Appeal Decision

Appeal Ref: APP/R4408/D/21/3288328

34 Staincross Common, Staincross, Barnsley S75 6NA

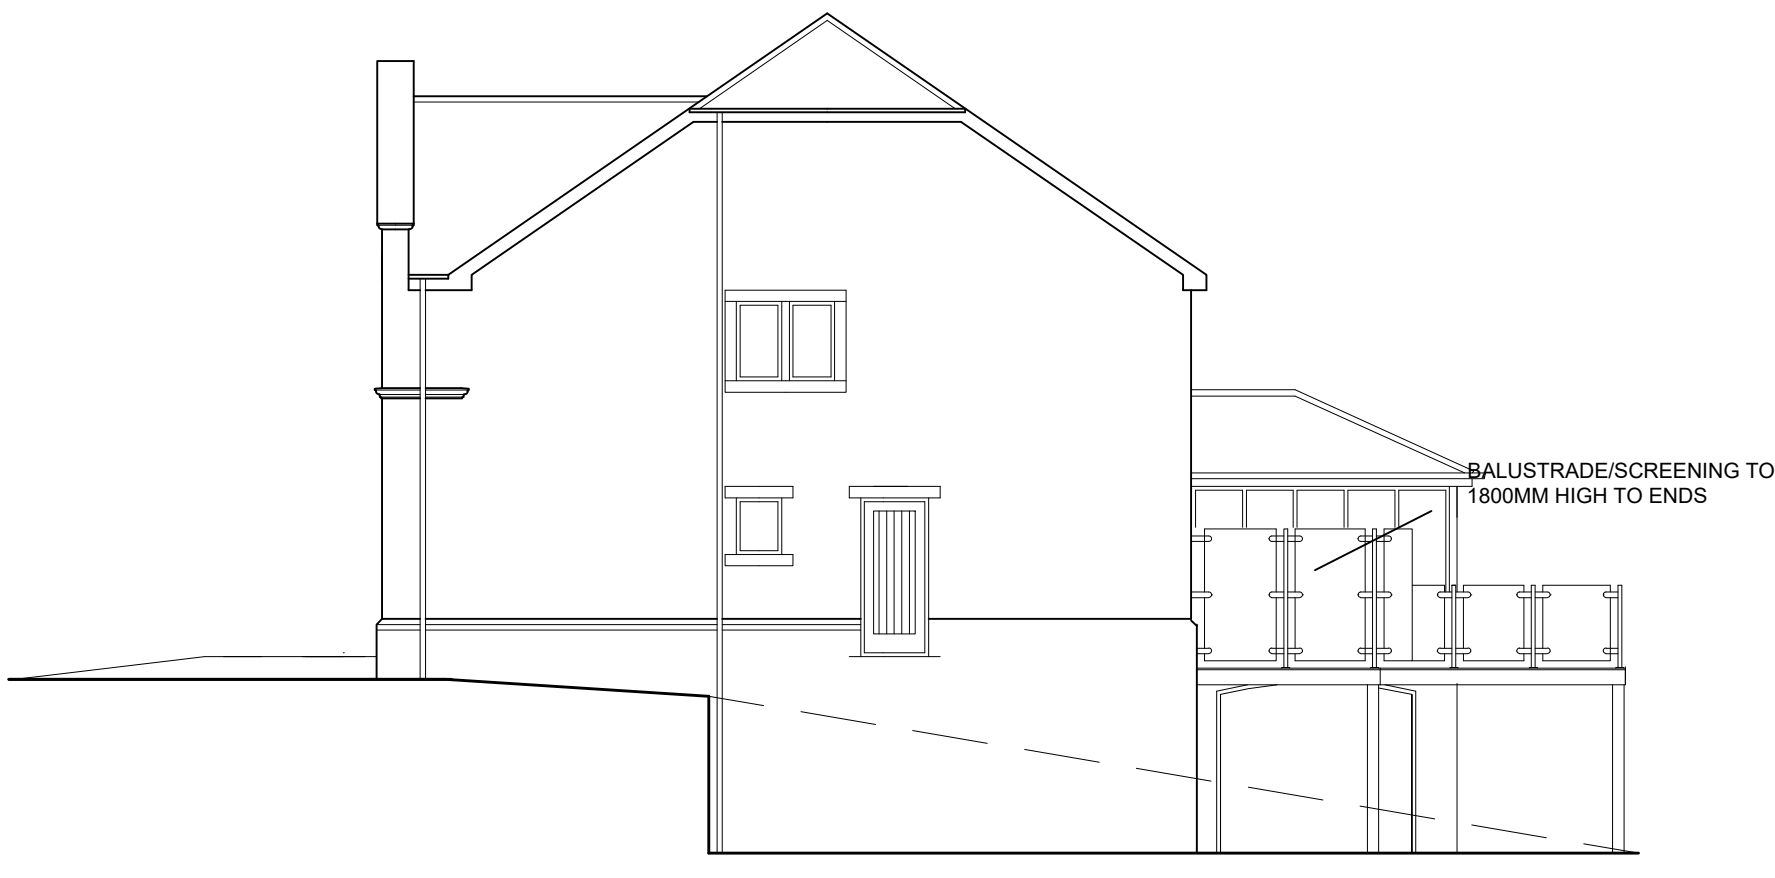
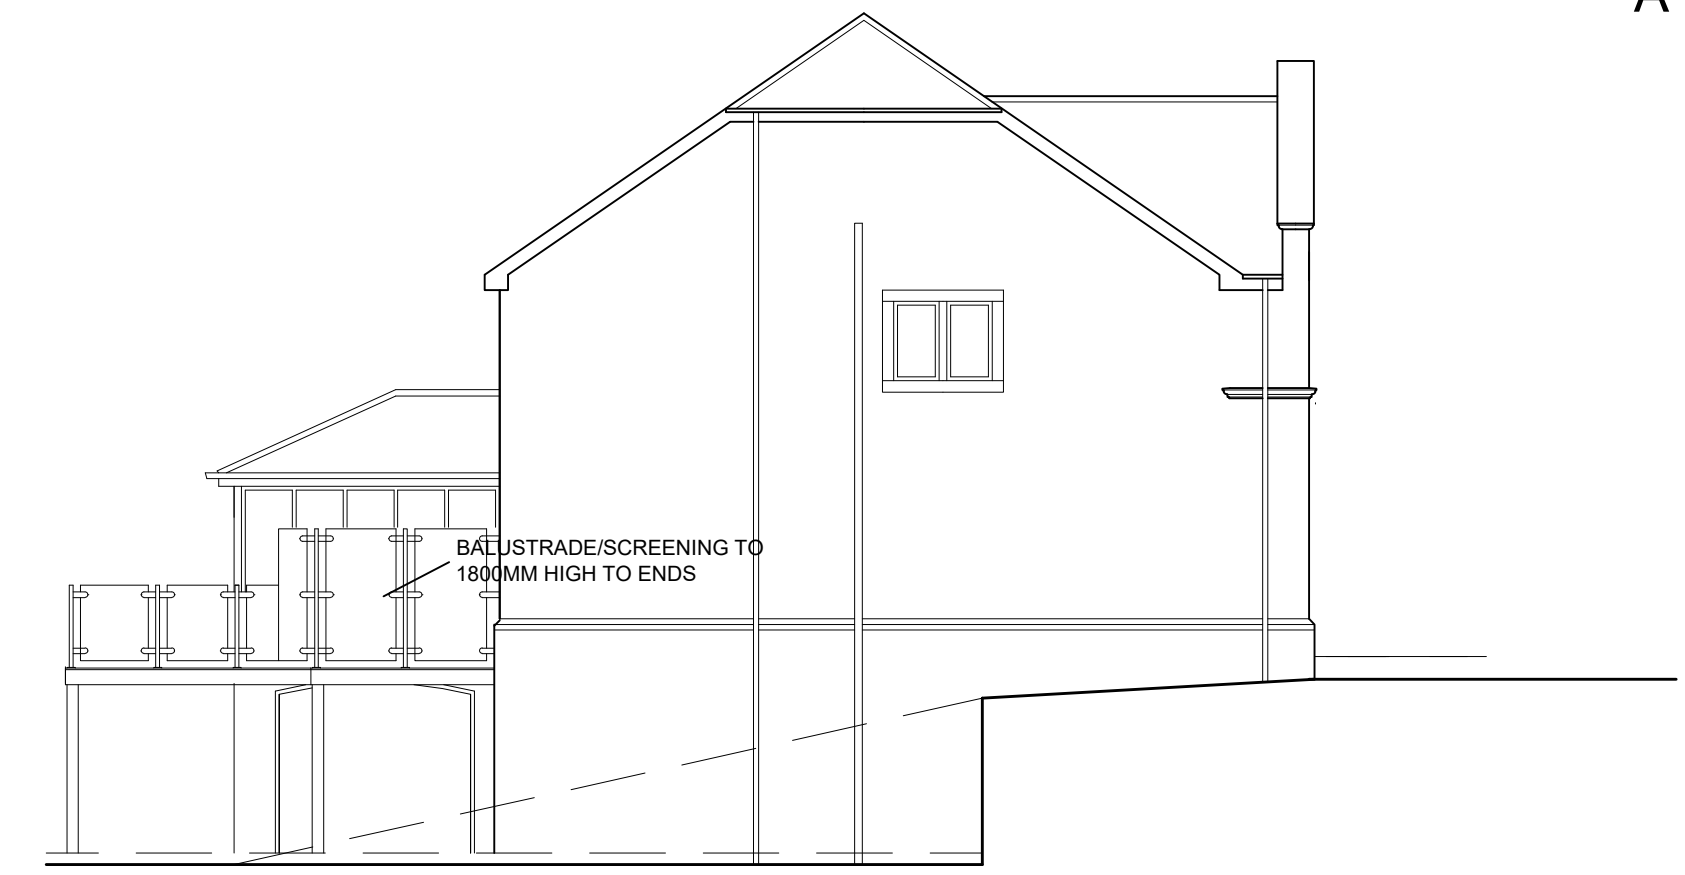
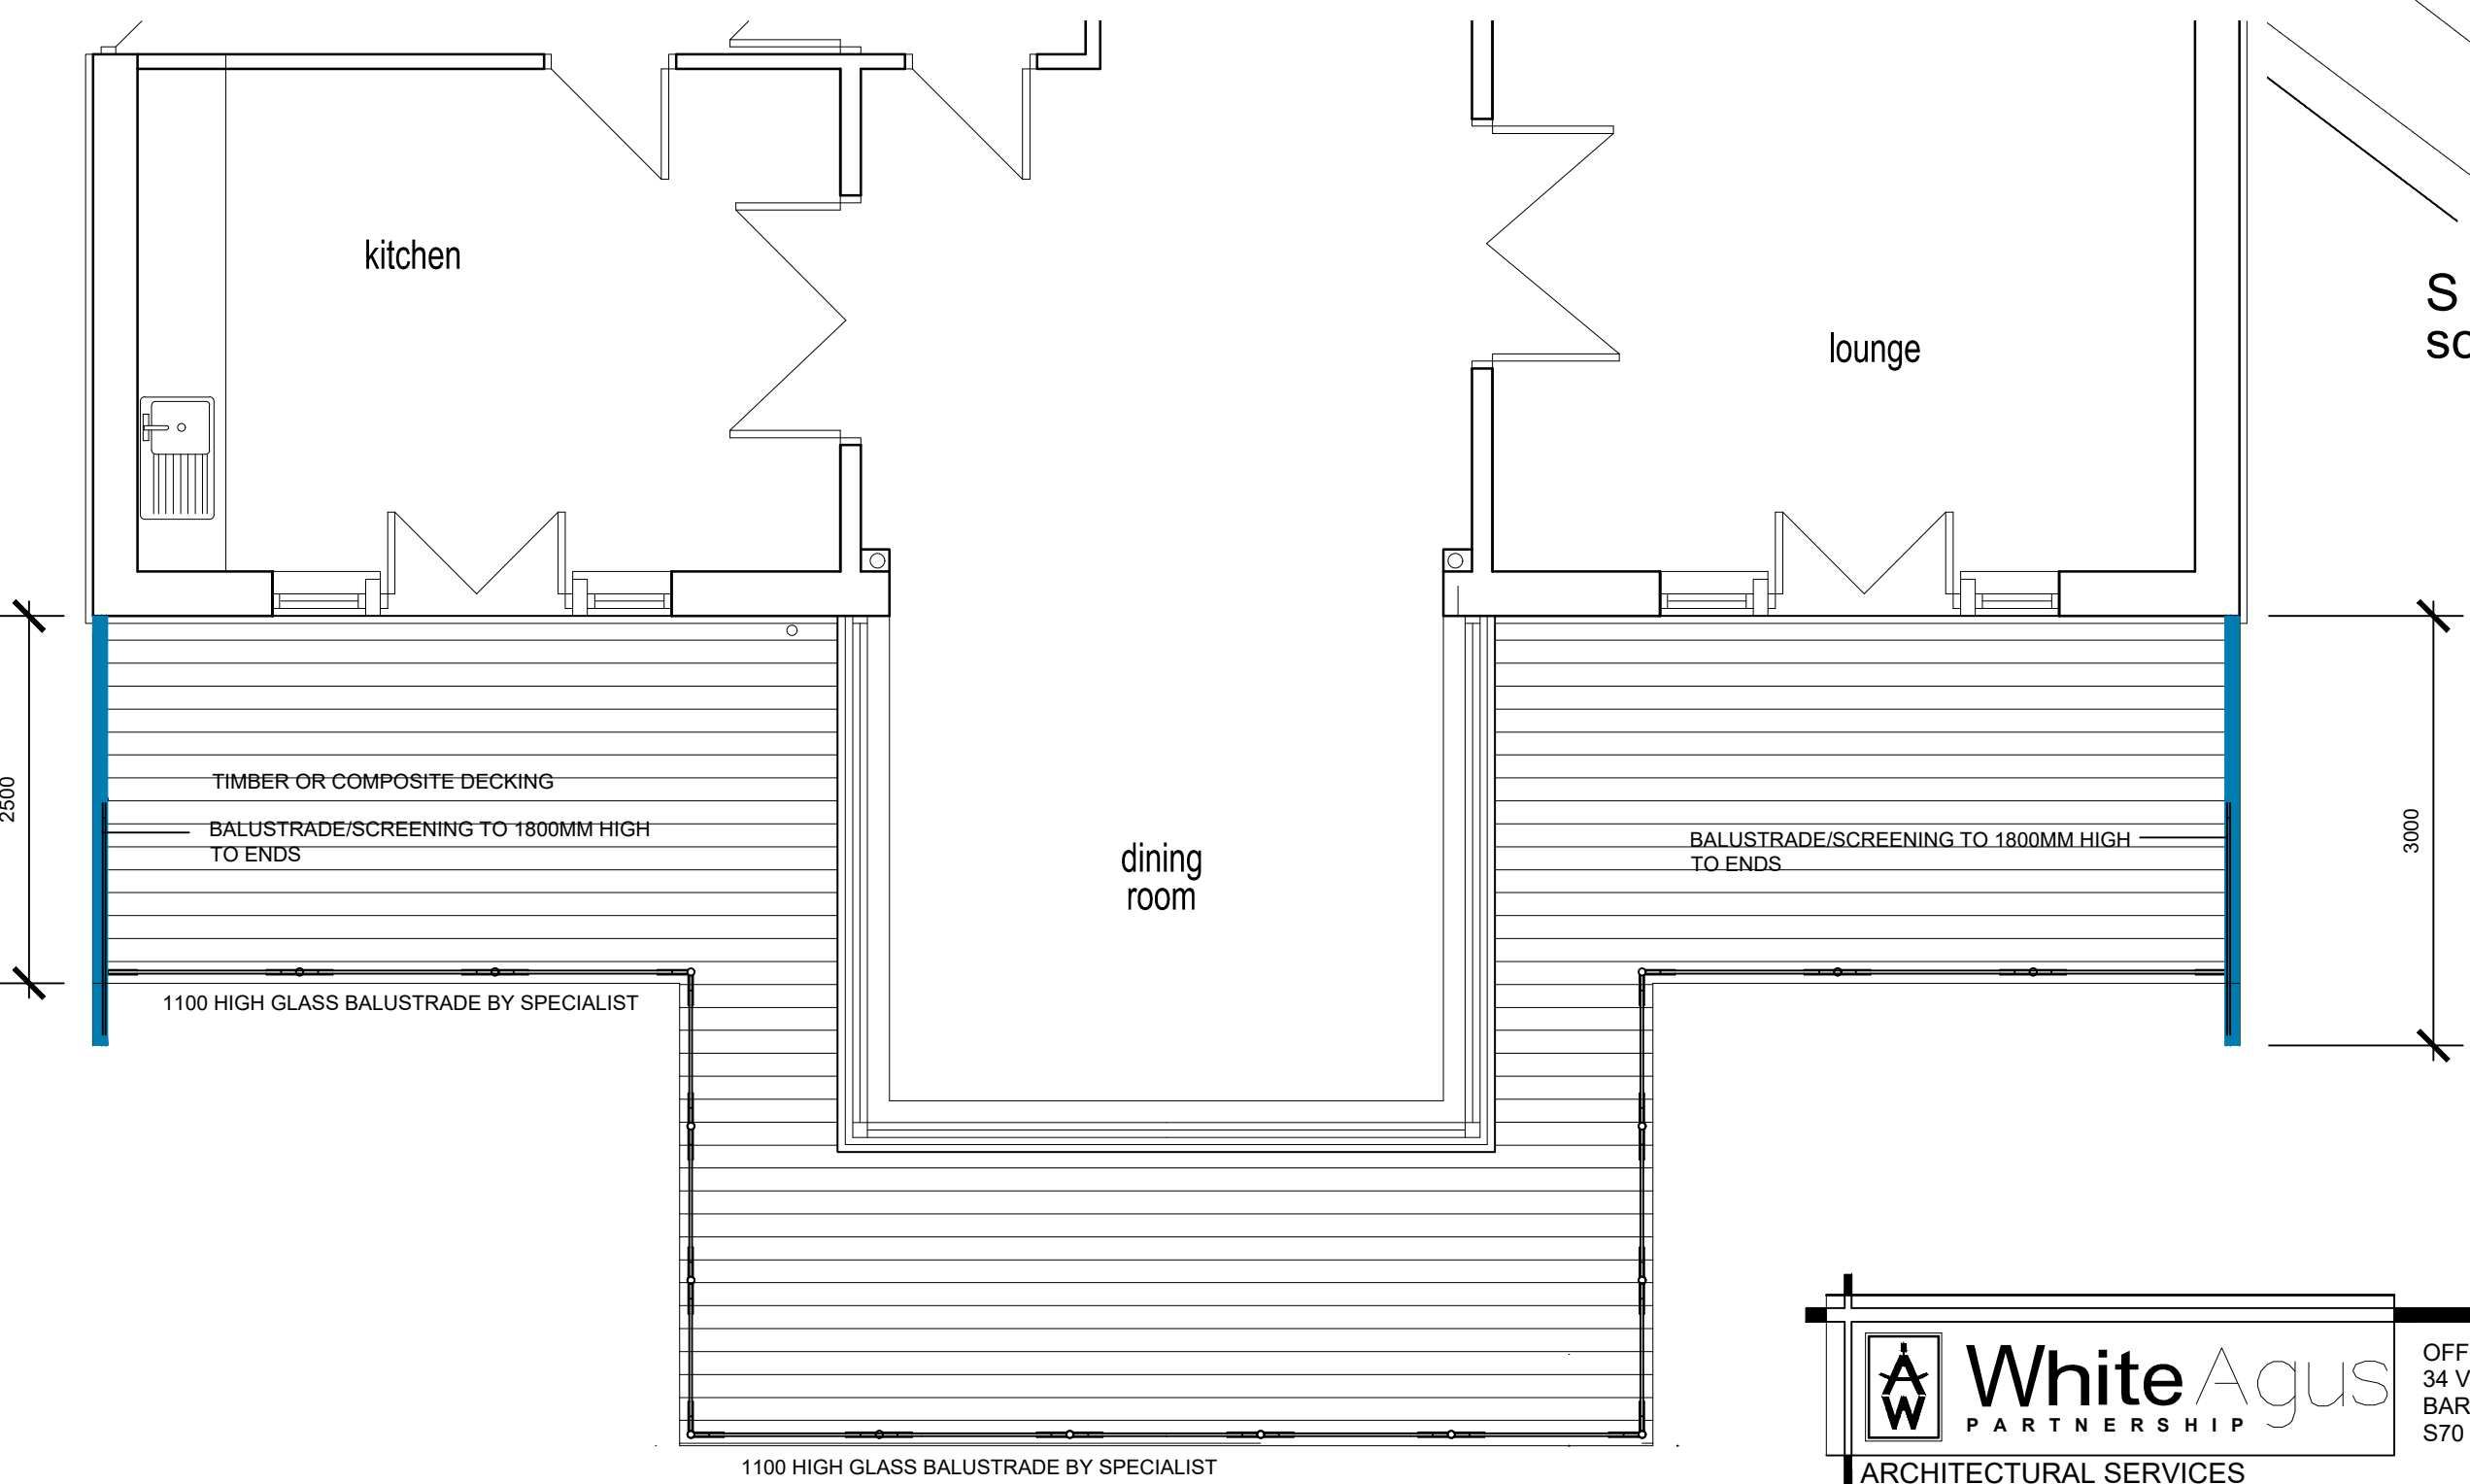
6. The proposal would consist of a first floor balcony to the rear of the house. The balcony would run along the main building and then around the central extension. The balcony sections facing the garden would project by approximately 2.5m from the main building and 2m from the central extension section. The sections to the sides of the central extension would project approximately 1m. The balcony would have 1.8m high screens to its main

building ends facing Nos 32a and 36, and 1.1m high balustrading to the remainder.

8. In contrast the proposed balcony would allow occupants much more freedom to move outside of the building and into an elevated and open position which would undoubtedly increase external activities and usage. This would also increase overlooking of neighbours and noise disturbance. As most of the proposed balcony would face directly down the garden then direct overlooking of neighbouring properties would be discouraged and would generally be acceptable. While it is recognised that the side sections of the proposed balcony would have only a 1m depth, this would not prevent the occupants of the appeal property standing in this area. In the absence of appropriate screening, the sides of the proposed balcony adjacent to the central extension would result in a significant increase in direct overlooking of the neighbouring gardens.

10. While the proposal would retain the end screening at 1.8m consistent with the permitted balcony, it would remove the permitted balcony's 1.8m high central section side screening which provides some protection to the neighbouring properties from direct overlooking. The proposal provides no alternative protection for this and as such, the result would be an increase in overlooking to Nos 32a and 36's gardens which would harm the privacy of neighbouring occupants. In this regard, the proposed development would be more harmful than the fallback position.

11. While it is acknowledged that central side screens would adversely affect the outlook from the central extension's side windows, the introduction of the balcony increases overlooking of neighbouring gardens from these areas and the screening is required to prevent this.

12. The proposal would also project approximately 0.5m further from the main building than the permitted balcony. While this would provide some additional space for its use, the increase would be quite modest. No evidence to show that this would increase usage or activity has been provided and, in my view, there would be no significant change in this. On this basis, I consider that there would not be an increase in noise disturbance from this compared to the permitted balcony
